CITY OF ALBUQUERQUE

January 30, 2024

Re: Storage Building
1905 8th St NW
Traffic Circulation Layout
Architect's Stamp 03-29-23 (H14-D078)

TCL

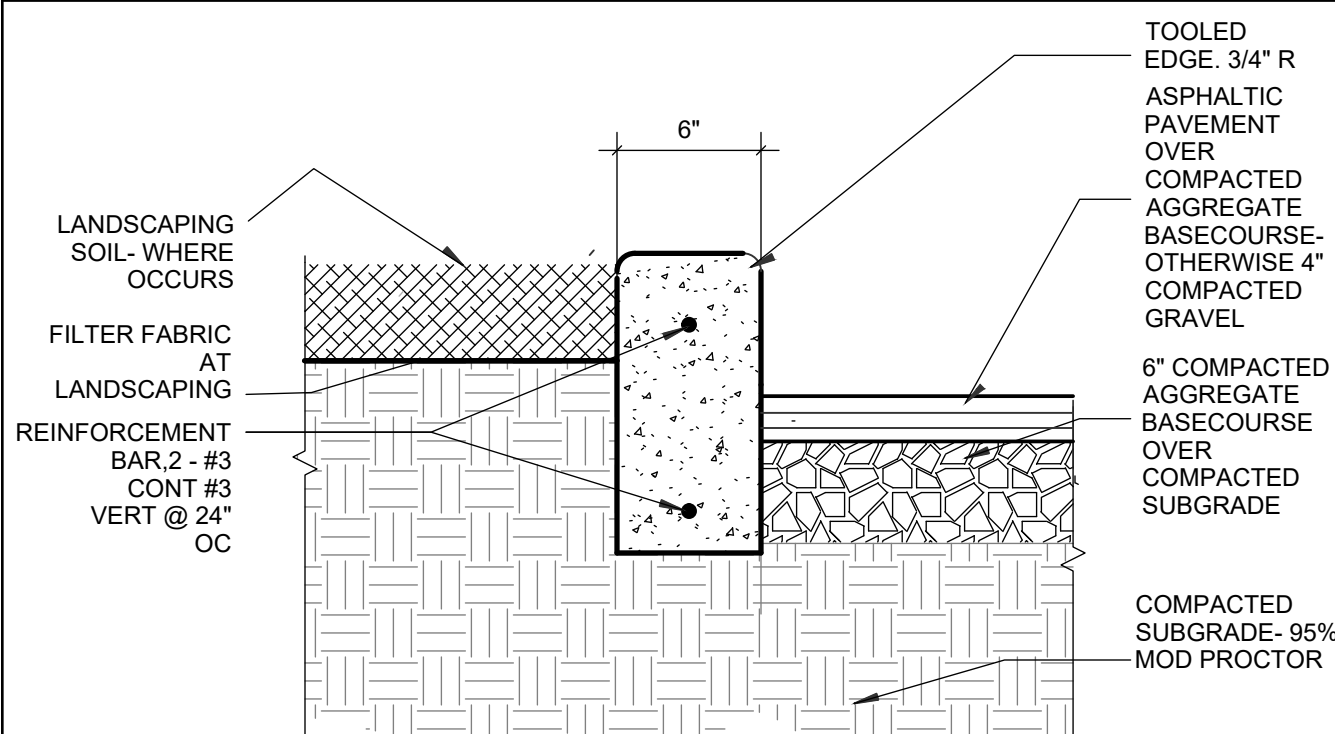
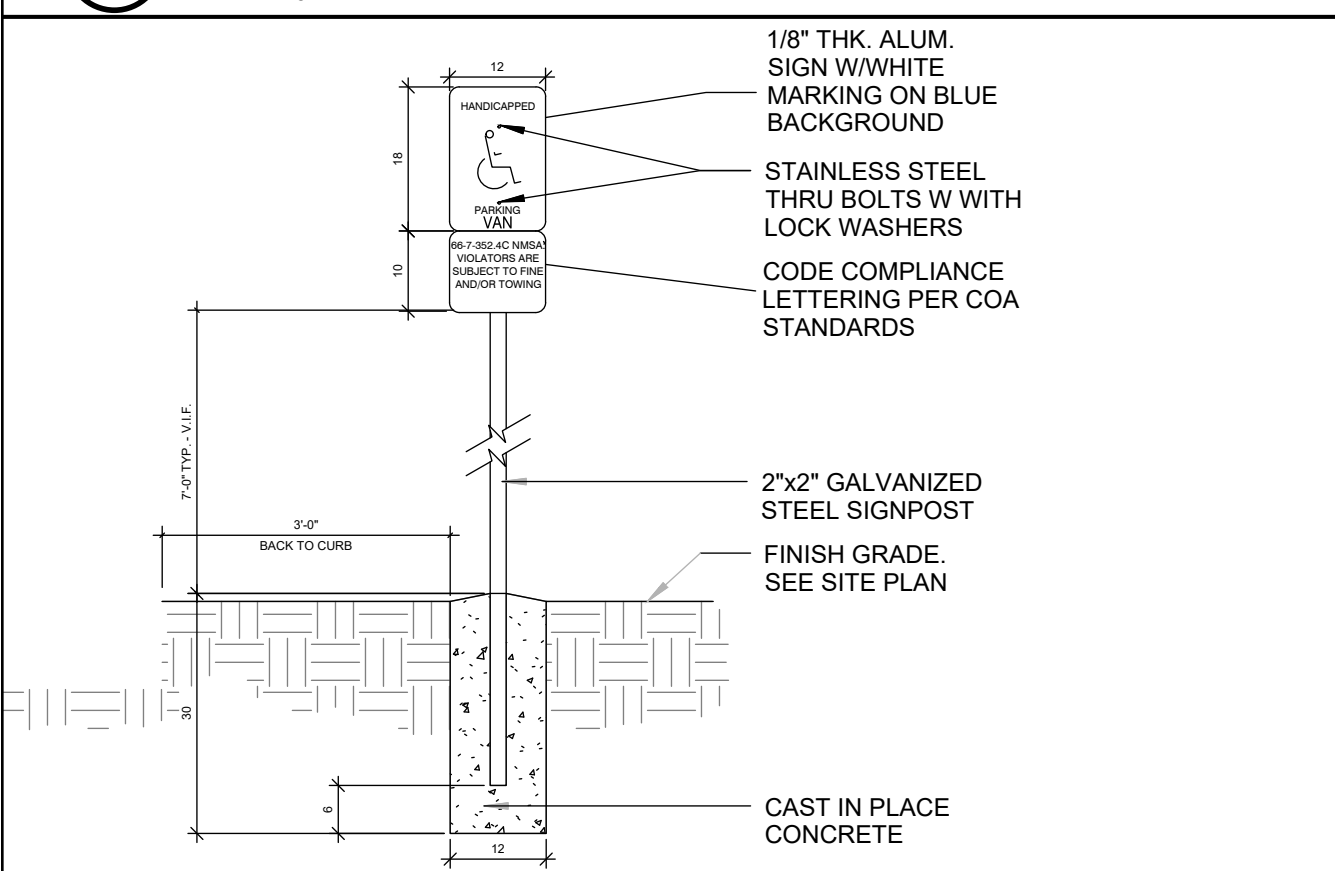
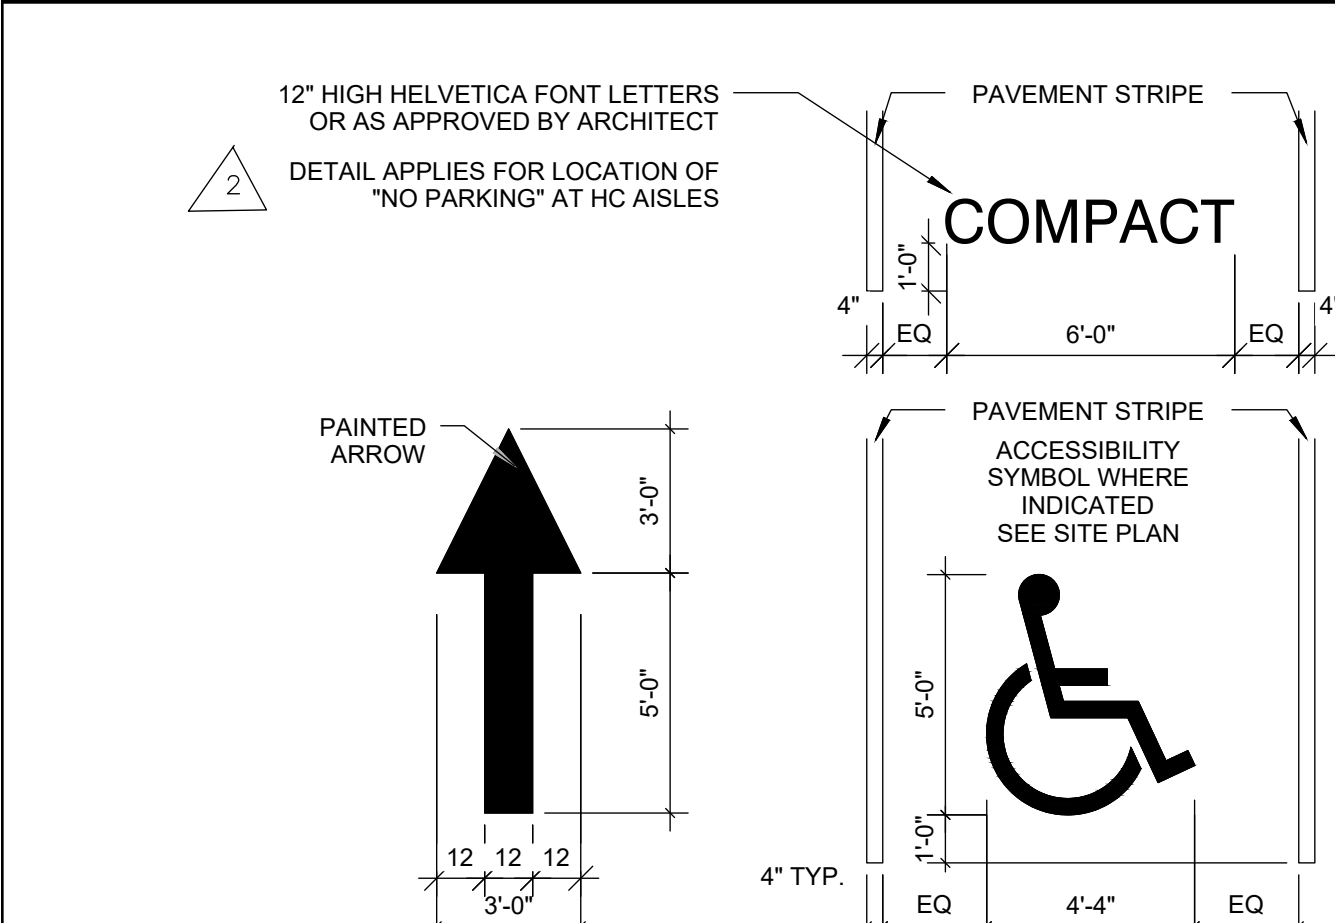
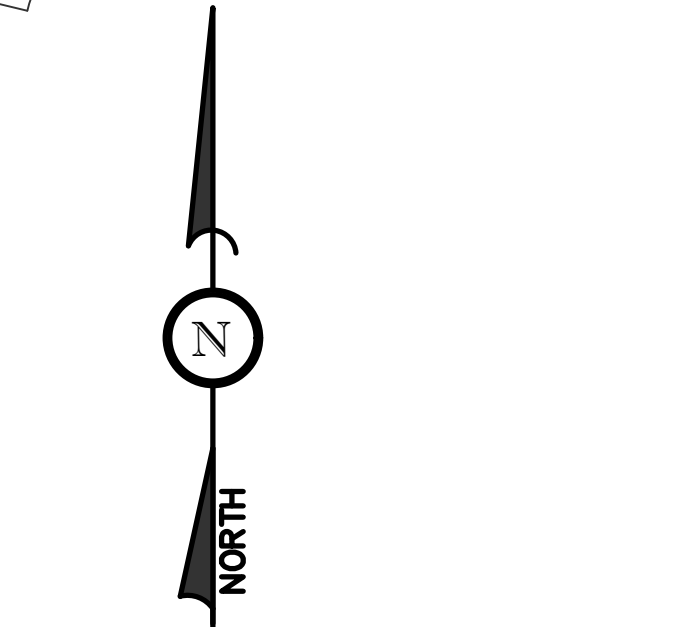
1. List the number of parking spaces required by the IDO as well as the proposed number of parking spaces including bicycle and motorcycle parking.
2. Identify all existing access easements and rights of way width dimensions.
3. Identify the right of way width, medians, curb cuts, and street widths on 8TH St.
4. 5 ft. wide sidewalk must be developed from property line to property line off 8TH St. for sidewalk waiver, please contact Ernest Armijo at earmijo@cabq.gov (505)924-3991.
5. Sidewalk along streets should be placed at the property line.
6. When sidewalk constructed, please ensure to provide 4 ft. wide pathway around the existing power pole. See attached city requirements.

7. Due to proposing a gate, please show on the site plan 20 ft. distance from the face of the curb to the proposing gate.
8. Please show on the site plan the building main entrance.
9. The ADA accessible spaces must include an access aisle. Van accessible aisles should be 8ft wide; all others should be 5ft wide.
10. The ADA access aisles shall have the words **"NO PARKING"** in capital letters, each of which shall be at least one foot high and at least two inches wide, placed at the rear of the parking space so as to be close to where an adjacent vehicle's rear tire would be placed. (66-1-4.1. B NMSA 1978)
11. Please place the ADA parking aisle adjacent to the 7 ft. wide pathway to provide efficient and safe ADA pathway.

12. The pavement marking "MC" should be shown in the opposite direction for motorcycles entering the parking space.

13. Provide a copy of Fire Marshal and Solid Waste approval.
14. Show the clear sight triangle on the site plan.
15. Please specify the City Standard Drawing Number when applicable.
16. Provide notes showing what work is included and on the work order and the private work on site.
17. Traffic Studies: See the Traffic Impact Study (TIS) thresholds. In general, a minimum combination of 100 vehicles entering and exiting in the peak hour warrants a Traffic Impact Study. Visit with Traffic Engineer for determination, and fill out a TIS Form that states whether one is warranted. In some cases, a trip generation may be requested for determination (**Contact Matt Grush: mgrush@cabq.gov**).
18. Please provide a letter of response for all comments given.
